Date 20 July 2026

BE/40/26/DOC - Chalcroft Nurseries & Garden Centre, Chalcraft Lane, Bognor Regis, PO21 5TS

Application under Section 73 for the variation of condition imposed under BE/81/20/OUT relating to condition 3 -approved plans and 18-access (conditions further amended by BE/77/25/NMA) BE/13/24/S73 Conditions(s) 22 - surface water drainage 23 - maintenance and management of surface water drainage.

CLIENT		Chalcroft Associates LLP	
PROJECT		Chalcroft Nursery, Bersted	
TITLE		Site Layout - Drainage And Levels	
DRAWN		DATE	PROJECT NO.
A Davies		May 2026	24123
ENGINEER		CHECKED	DRG NO.
S Doughty		SRD	101
SCALE		1:200 @ A1, 1:400 @ A3

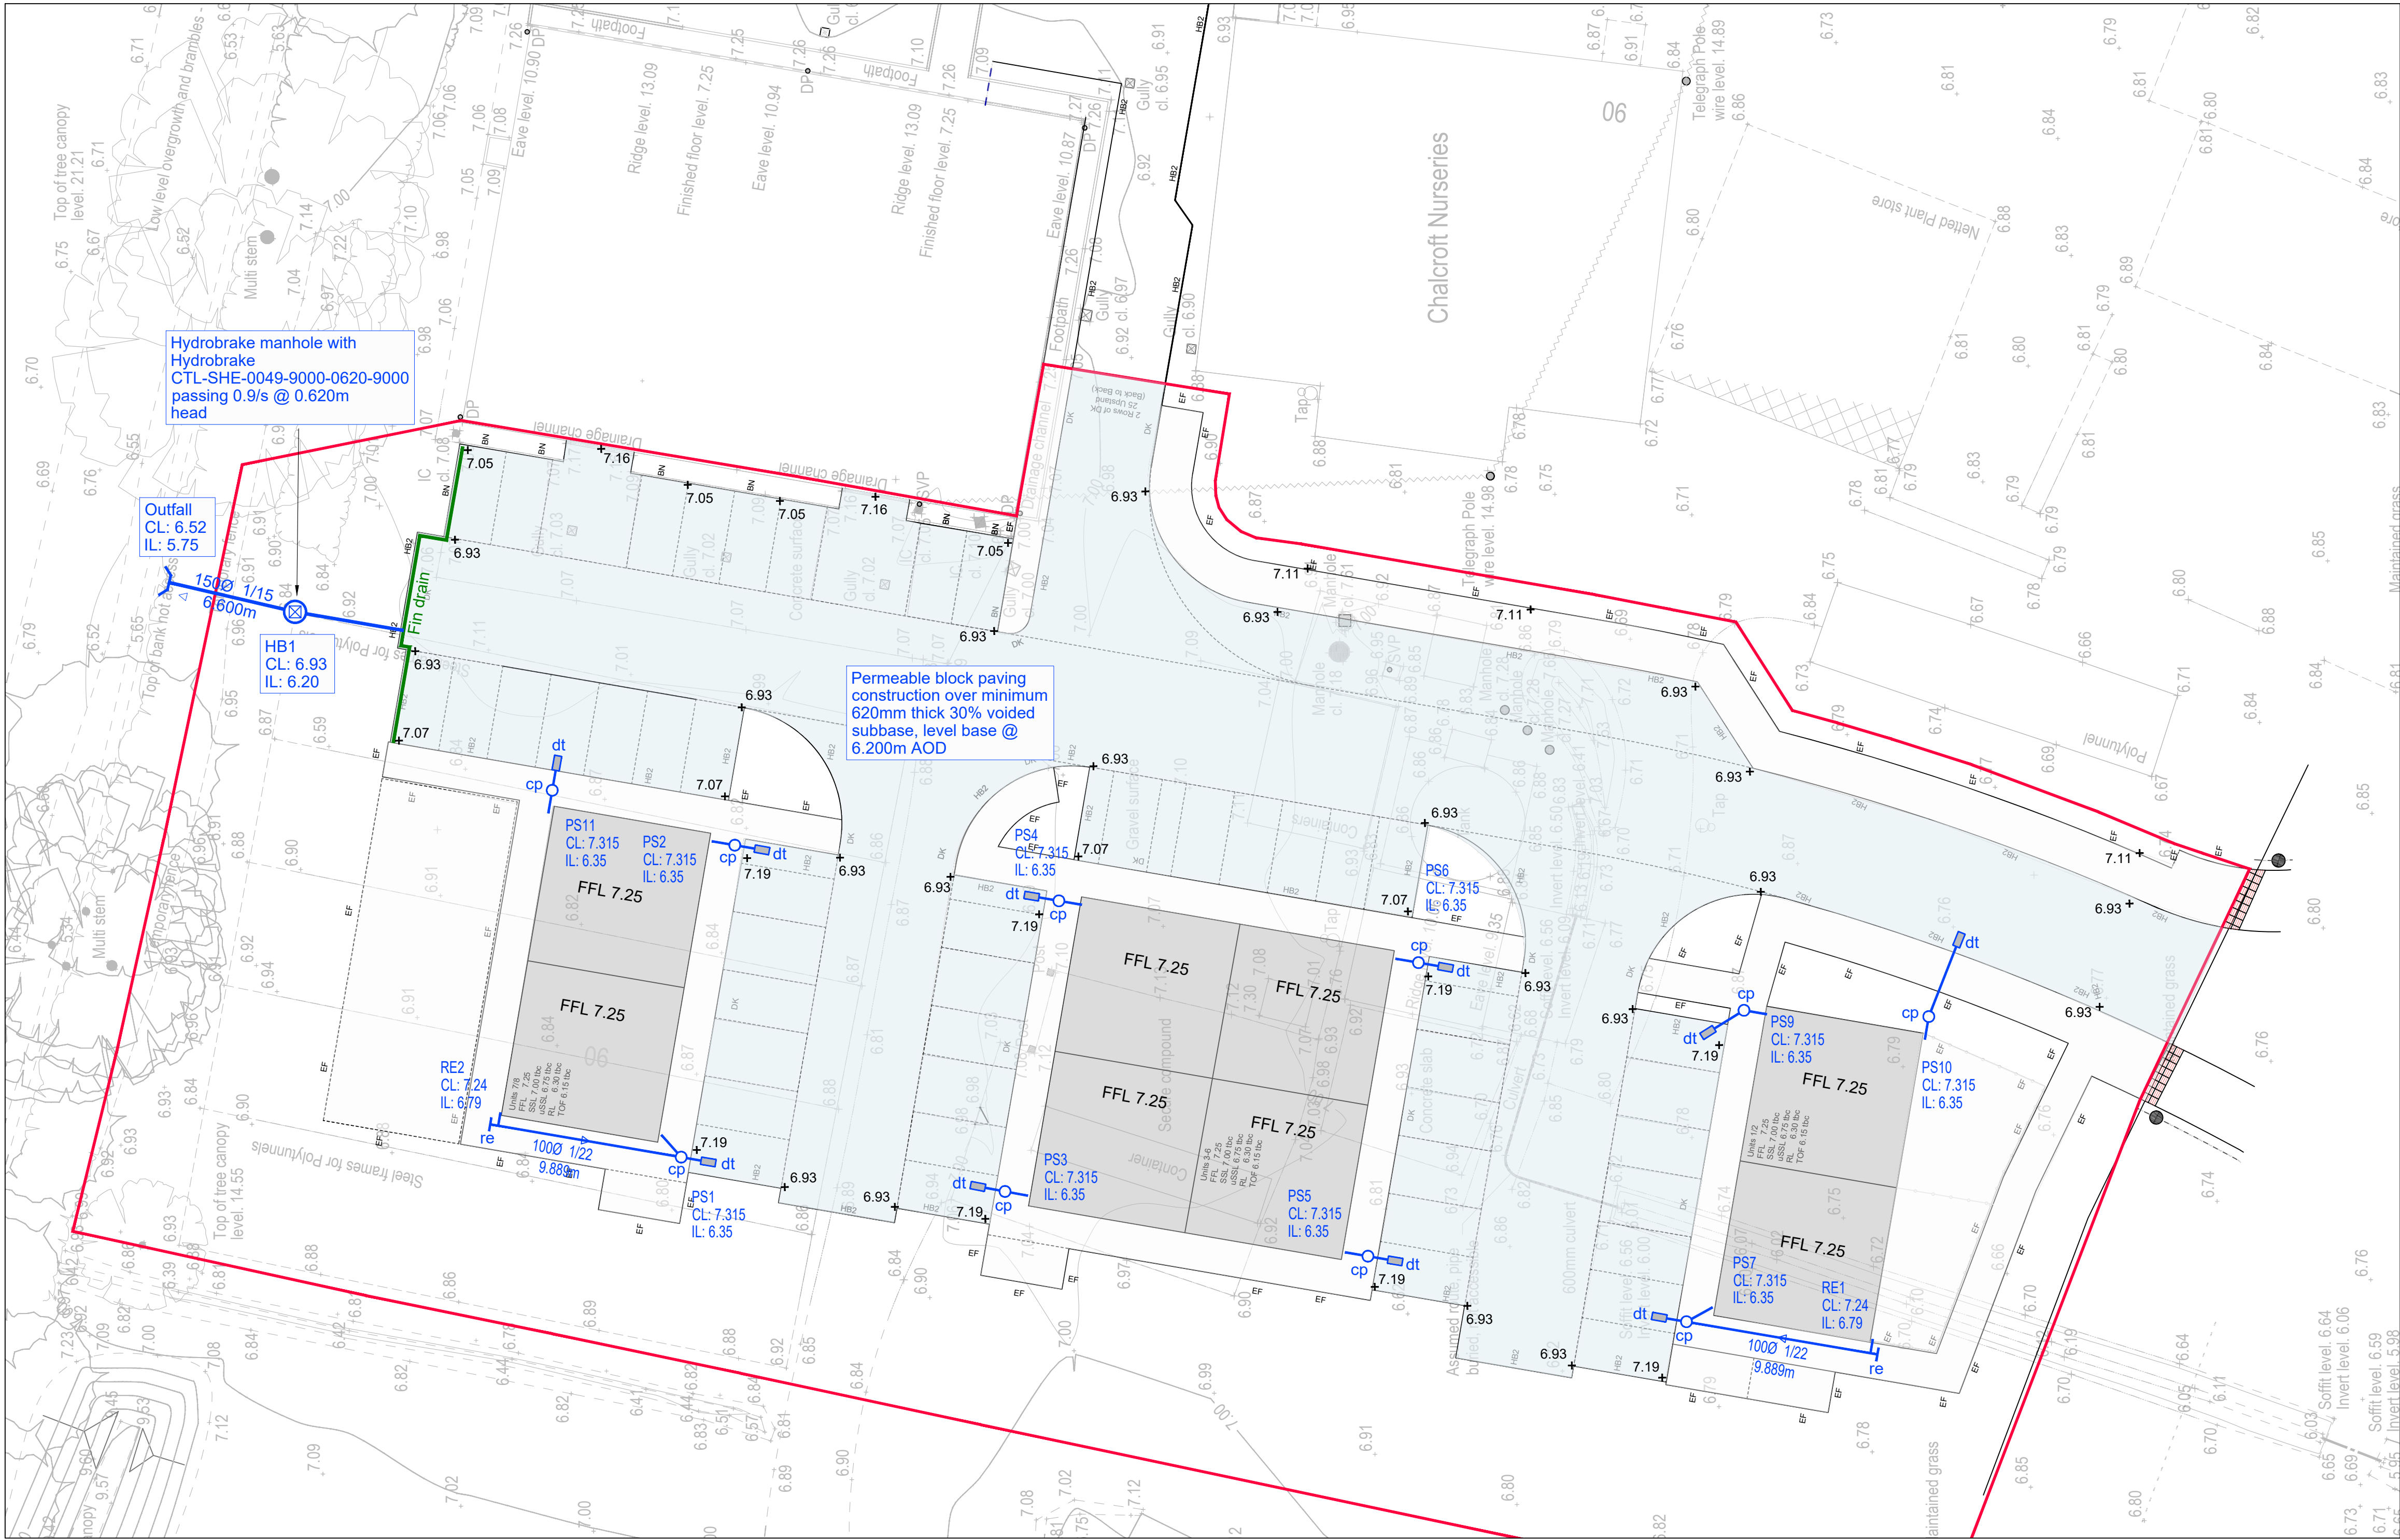
The drainage strategy proposes discharge to an ordinary watercourse via a new headwall connection. Whilst this does not represent a planning compliance issue, it should be noted that the discharge point is outside of the red line boundary, and you will need to be satisfied that suitable permissions are in place for this connection.

1. Exceedance Management – Further evidence is required to demonstrate how any exceedance flows would be safely managed across the site without increasing flood risk elsewhere.
